Ref: EP/2/21HH

Description of Works: Erection of front extension to create first floor balcony, following demolition of existing conservatory with changes to external materials and wall finishes.

Location: 27A Sea Lane, East Preston, BN16 1NH

Rear Elevation (east)

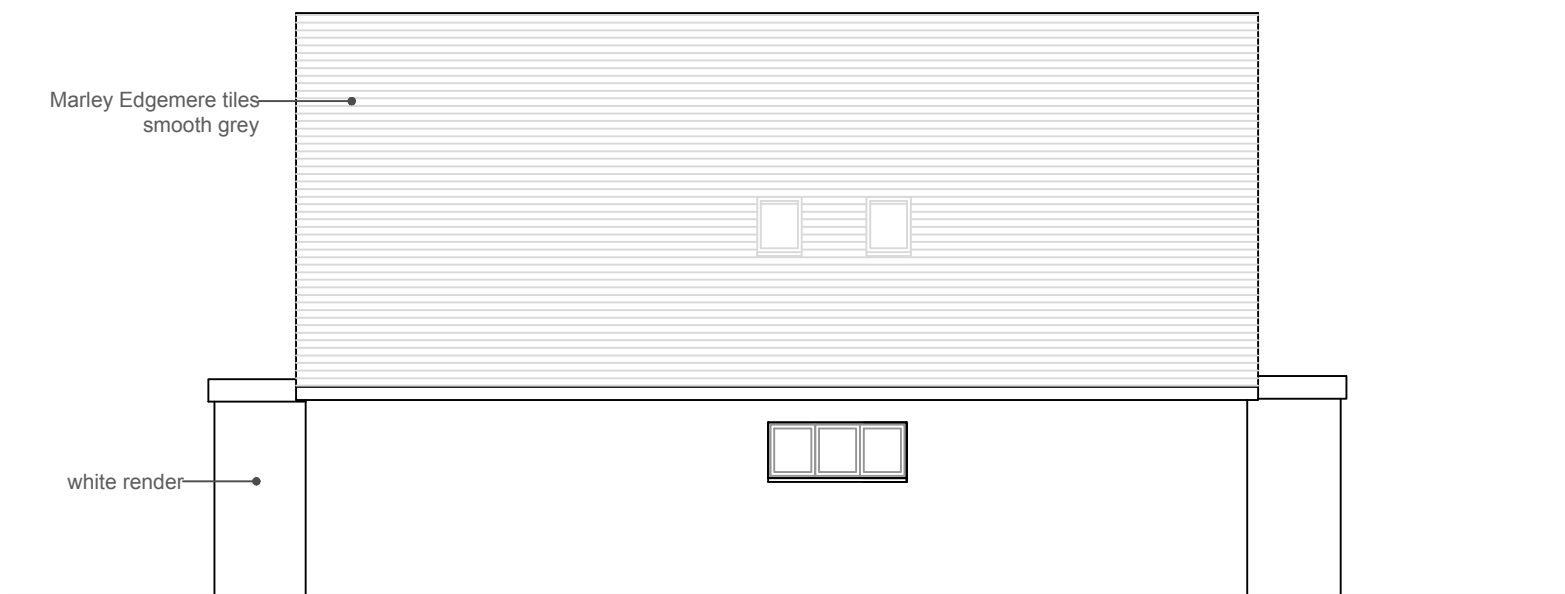
The sitting room in the annexe is approximately 11 metres from the proposed rear balcony (east elevation). And will be directly overlooked by the rear balcony. People on that balcony will be standing very close to the boundary at high level offering them excellent views over the majority of no.27 garden area and will be able to completely overlook the sitting room of the annexe which is the main inhabited space in this small annexe. I know how oppressive and intrusive this would feel as I have lived there. There would be nowhere where you couldn't be seen by people in No. 27a. It is a lovely sunny room, and you would not want pull curtains and net curtains would not be suitable over patio doors. The proposal would change this from a lovely usable space into a very uncomfortable one.
